**Re: StarBucks**  
**8721 Washington NE**  
**Traffic Circulation Layout**  
Architect's Stamp 12-04-2020 (C17-D128)

The TCL submittal received 1-28-2021 is approved for Building Permit with. A copy of the stamped and signed plan will be needed for each of the building permit plans. Please keep the original to be used for certification of the site for final C.O. for Transportation. Also, please note that all public infrastructure that is required to be constructed within public right-of-way is required to go through the work order process for further review and approval.

## Architect's Response Letter

**Project:** Starbucks – Alameda & Washington

### A3 ARCHITECTURAL SITE PLAN

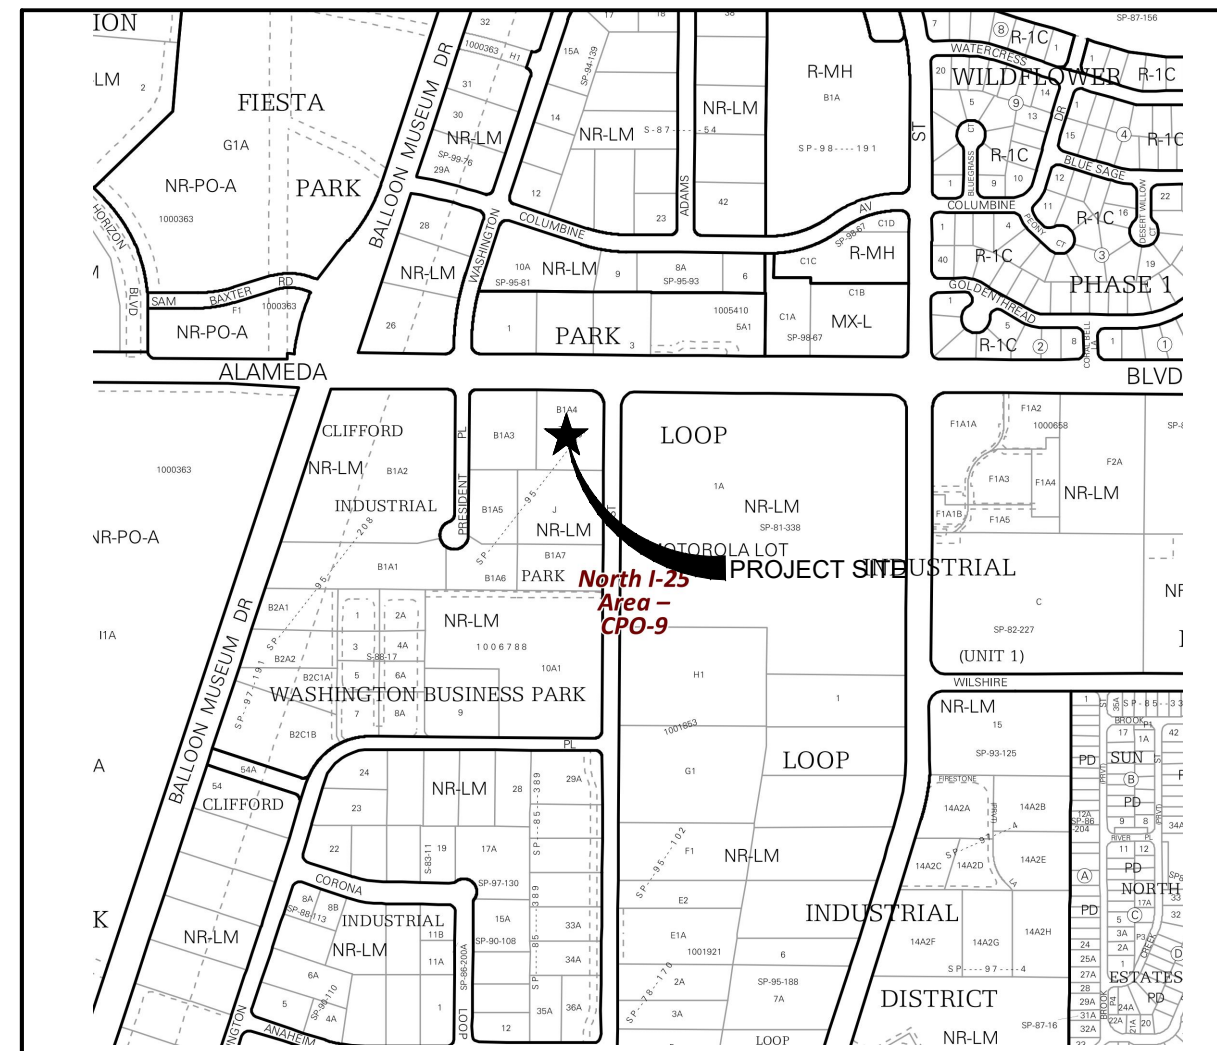
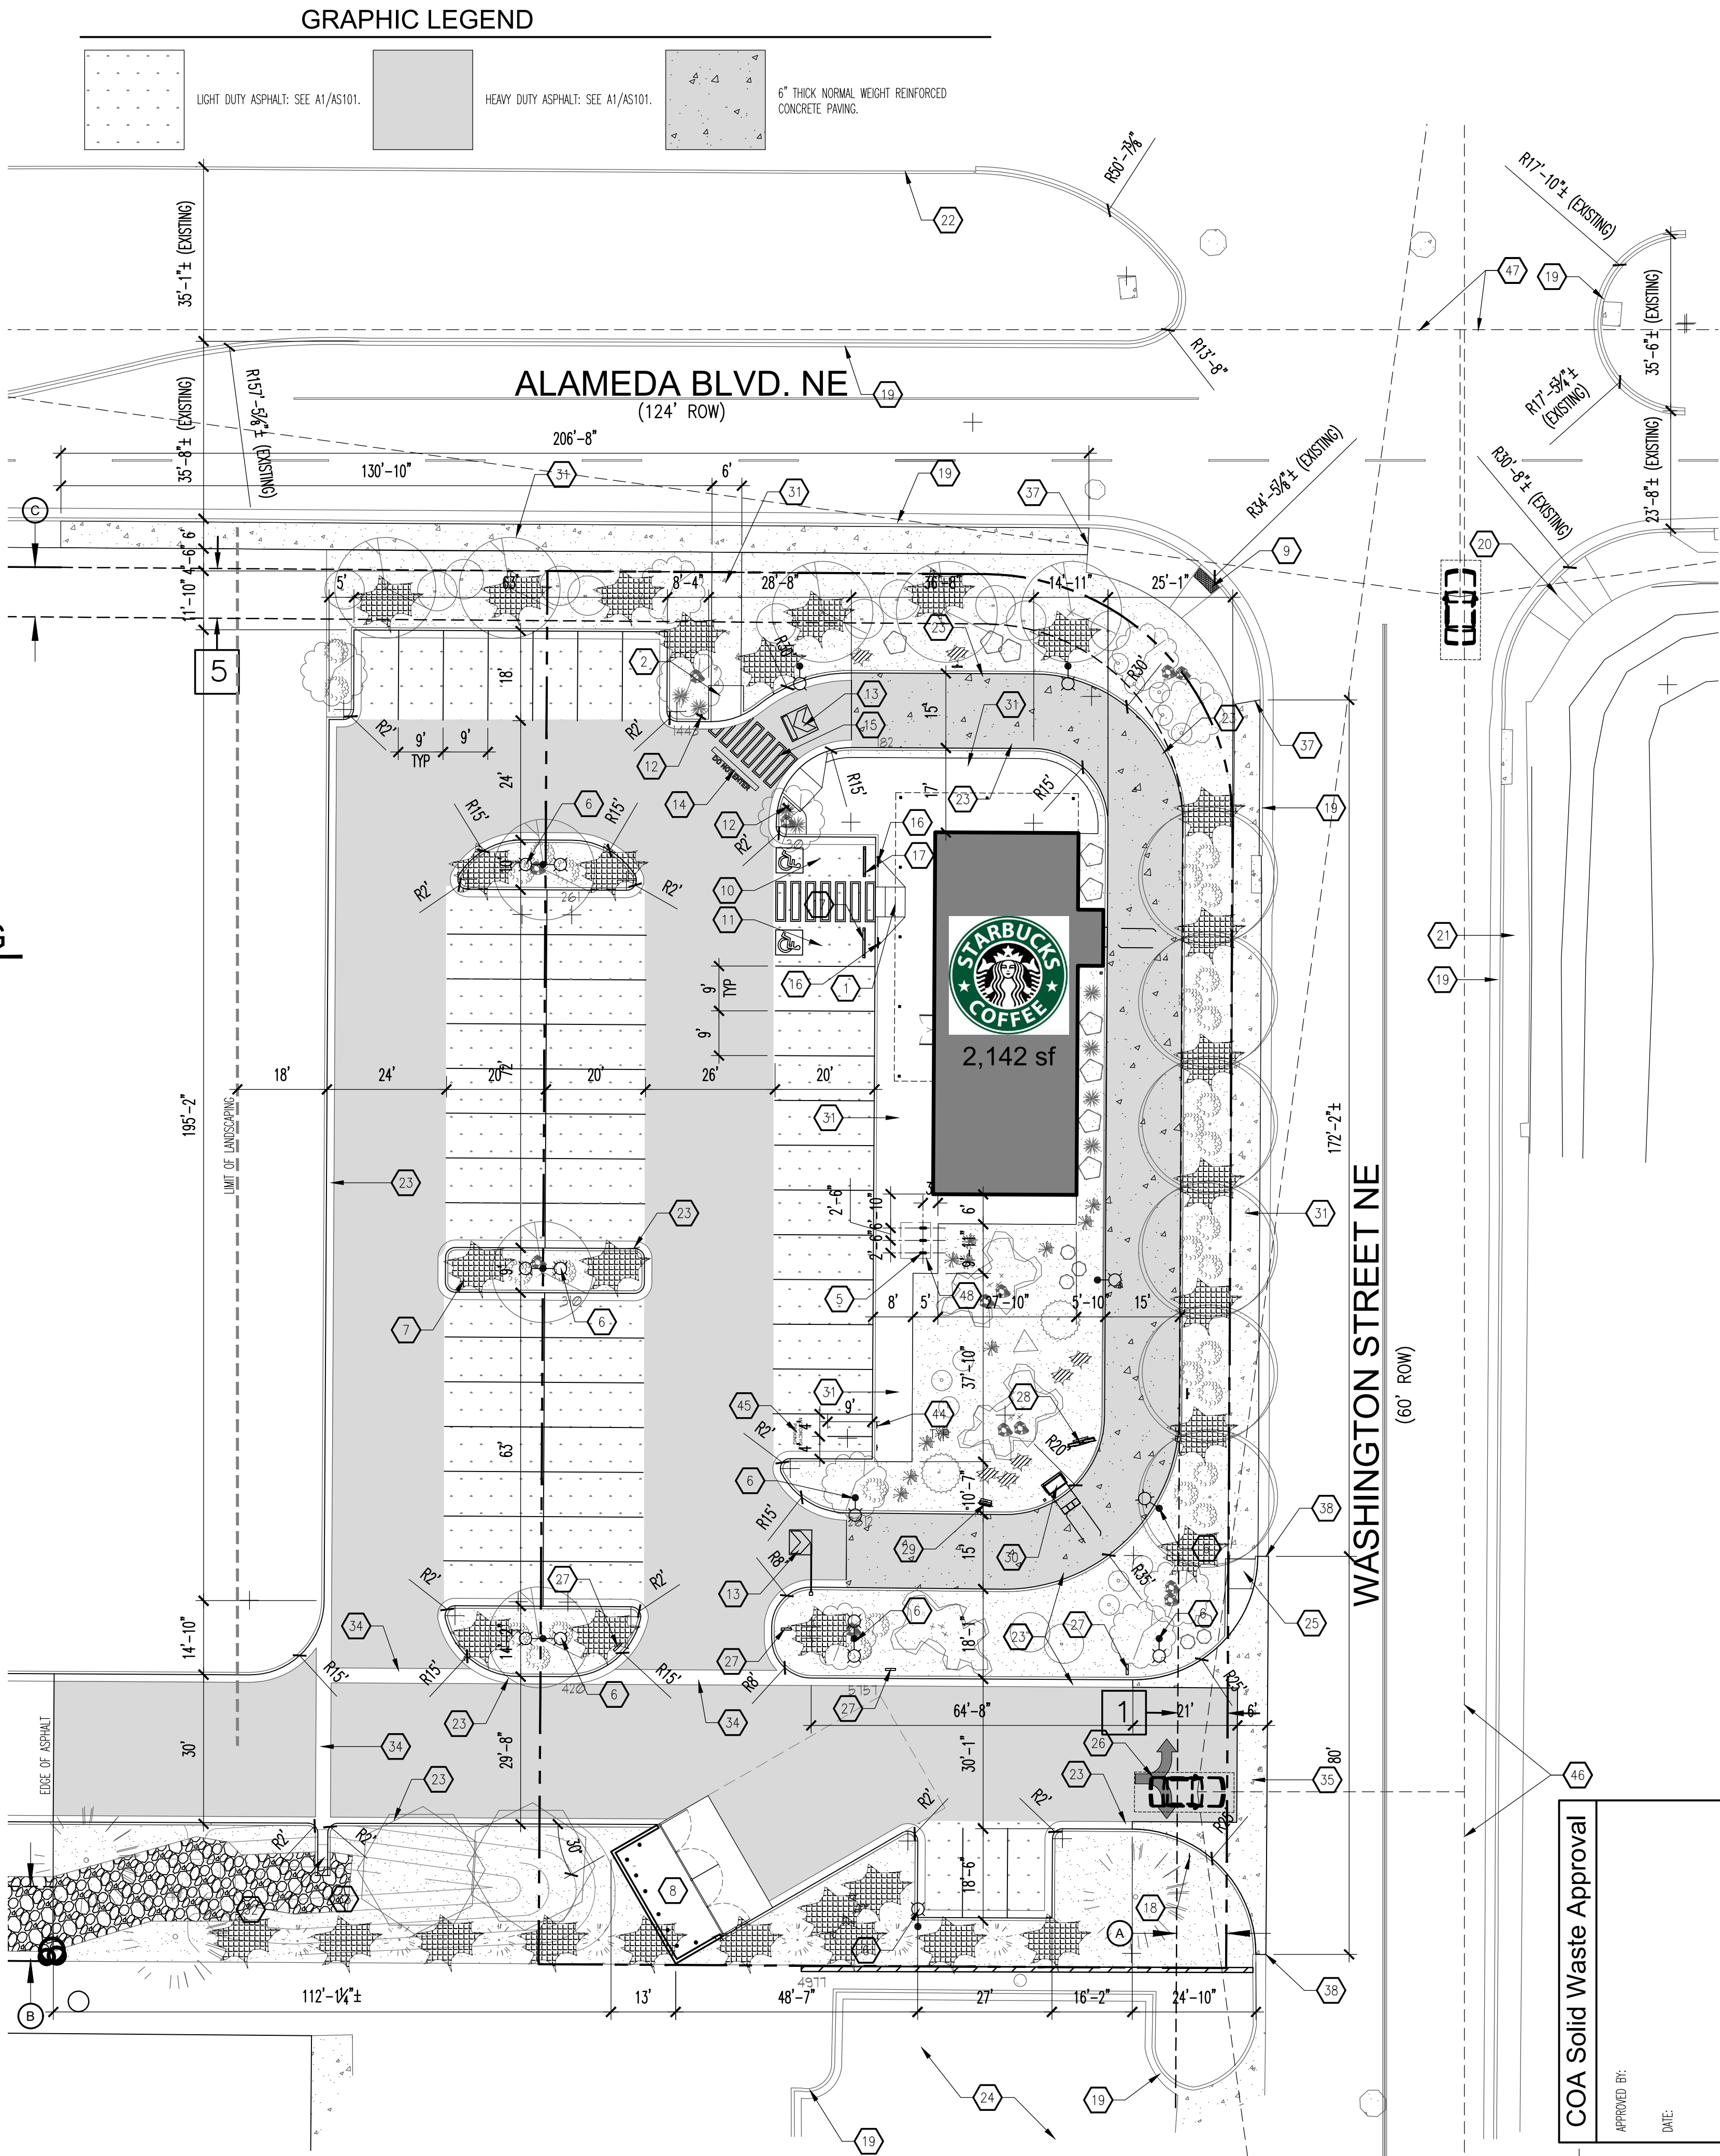
1. Traffic Circulation layout must be stamped, signed, and dated by an engineer or architect licensed in the state of New Mexico.

Refer revised site plan sheet AS101 and Site Details sheet A1.1.
